Application number: 2025/91657	
What is the application for?:	Erection of first floor side extension (within a Conservation Area)
Address of the site or building:	Kelvin Villa, 1, Newsome Street, Dewsbury, WF13 4HE
Postcode:	WF13 4HE

PROPOSED FRONT ELEVATION
1:100 @ A1

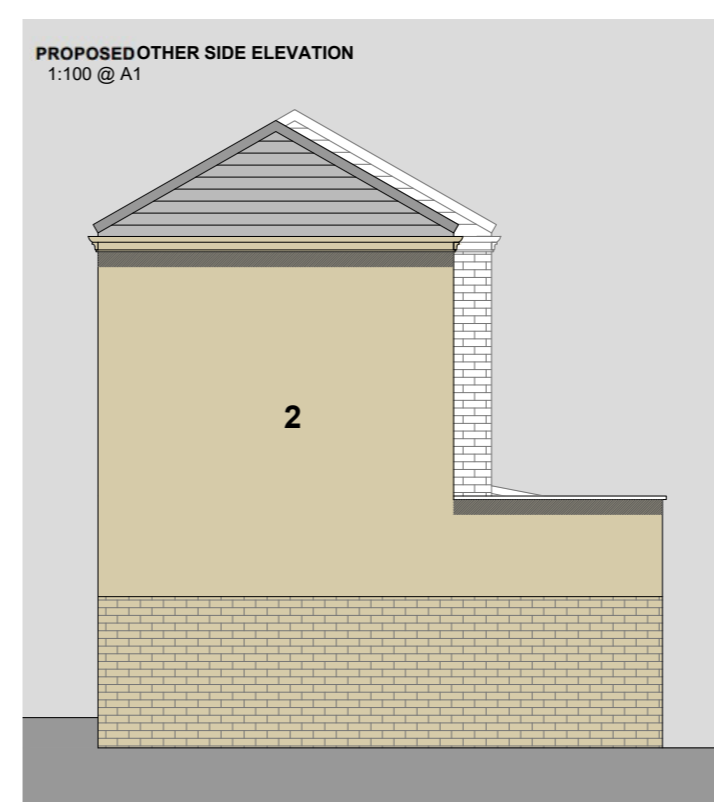
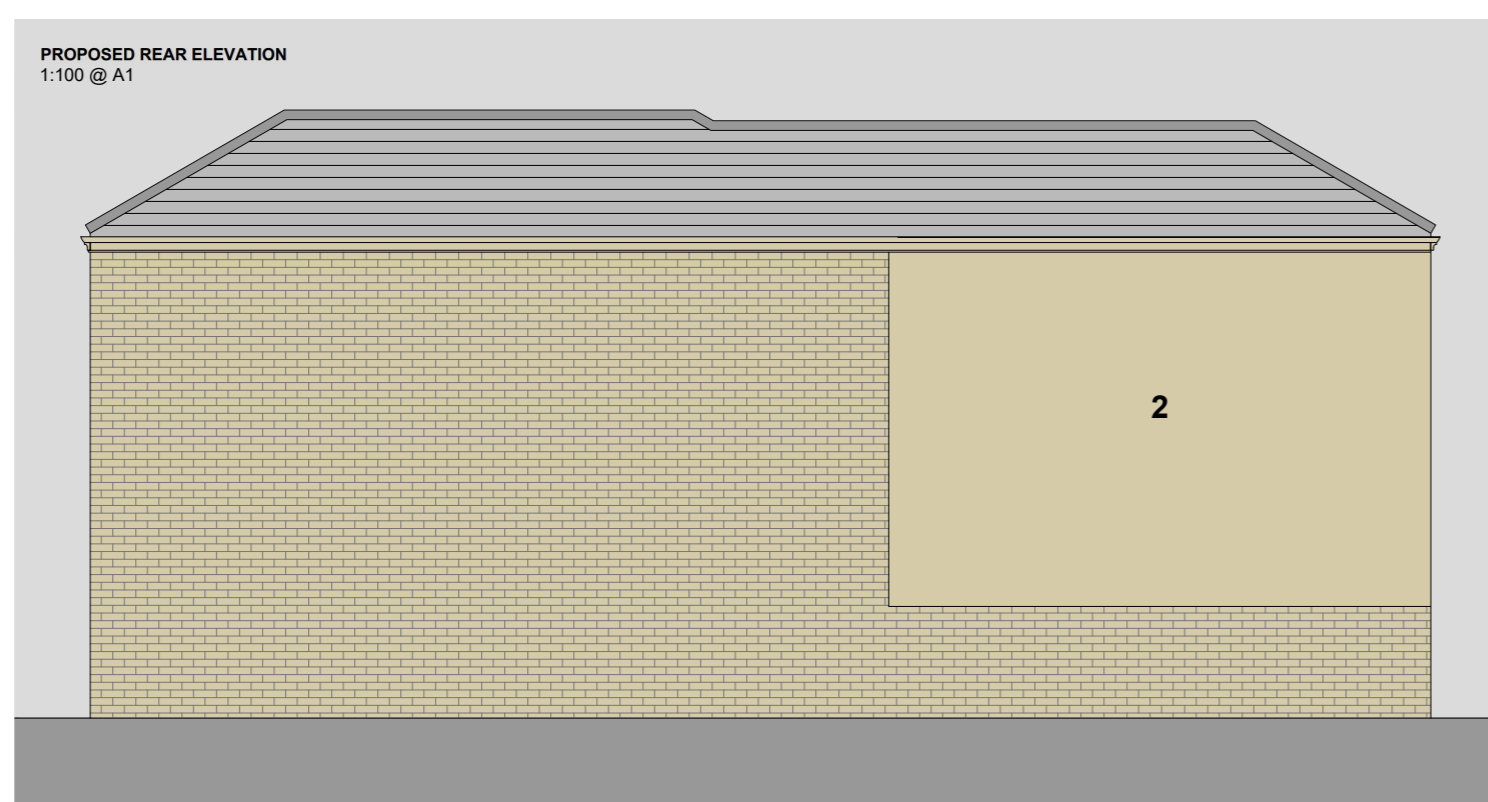
<p>2. Harm to the Character and Appearance of the Conservation Area</p>	
<p>The proposed extension is excessive in scale, bulk, and massing and is not sympathetic to the architectural character of neighbouring properties or the established appearance of the Conservation Area. The design fails to preserve or enhance the area's historic and aesthetic value, as required by Section 72(1) of the Planning (Listed Buildings and Conservation Areas) Act 1990, which places a duty on the local authority to pay special attention to preserving or enhancing the character or appearance of</p>

The proposed development would therefore harm the visual integrity of the Conservation Area and is inconsistent with Local Plan Policy LP35 (Heritage) and the National Planning Policy Framework (NPPF) paragraphs 199–208, which emphasise the importance of conserving heritage assets.

Due to its size and positioning, the proposed extension would block natural light to my property and neighbouring dwellings, resulting in an unacceptable loss of daylight and outlook. The proximity and height of the new structure would have an overbearing impact, diminishing the residential amenity of adjoining homes and failing to comply with Local Plan Policy LP24(c), which seeks to protect the amenity of existing and future occupiers.
